Application no: H18-0942-10

Description: Insertion of new double sash window on ground floor to north west elevation

Amendment: Amendments to window (dwg. nos. B2395/05C and B2395/10D)

**Re Insertion of Double Sash Window on Ground Floor to North West
 Elevation, Curlew Lodge, Guys Head Road, Sutton Bridge. H18 -
 0942 - 10**

Client	Mr & Mrs R Smith	Scale	1:50
Project	Proposed Alterations to Curlew Lodge Sutton Bridge	Date	17/12/2009
		Drawn by:	GAR
		Drawing No.	B2395/05
Title	Proposed Elevations	Revision	ABC

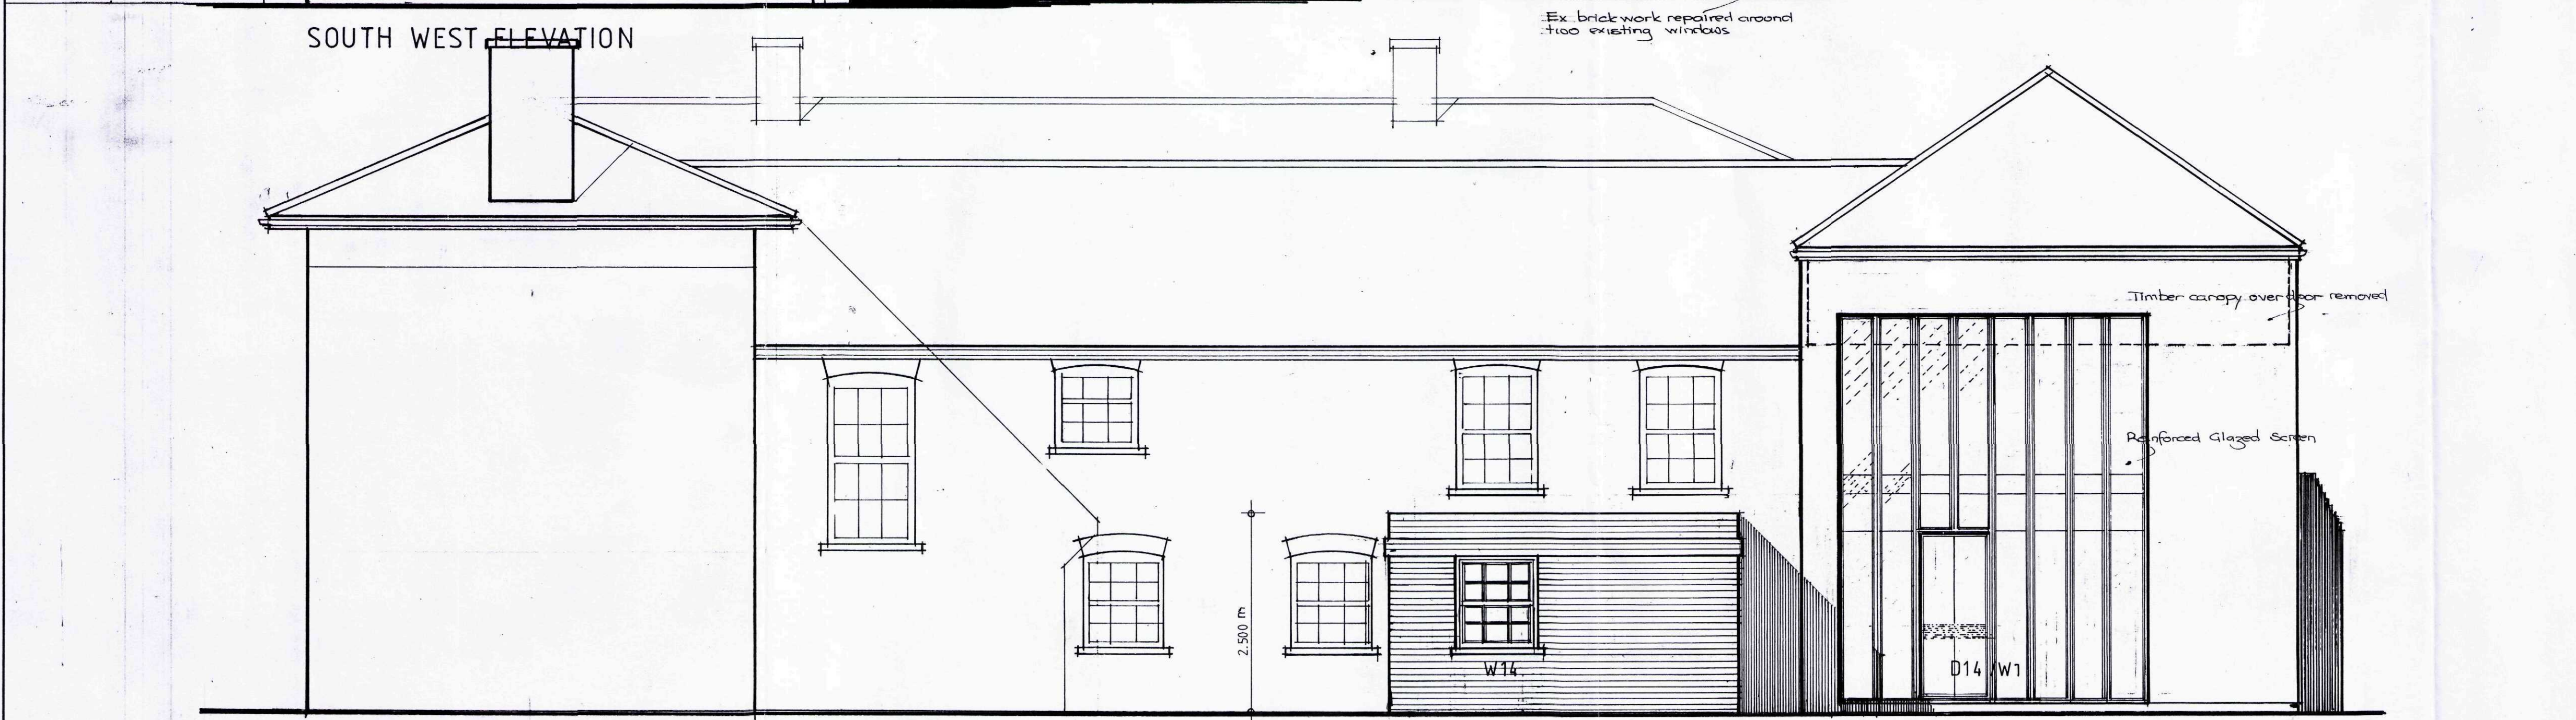
Further to recent communications regarding the above windows and your letter dated 17th November, please find enclosed for your file drawings B2395/5C and 10 D amended to reflect the simplified window as discussed.

Whilst supplying these drawings I would point out the addition of 3 no. tie iron pattresses to the north west elevation. The project Structural Engineer has suggested a need for them following a revision in the internal layout of the converted barn and we would wish these to be part of your consideration in your deliberation regarding the above Listed Building Application.

L addition addition of tie irons to north west elevation.
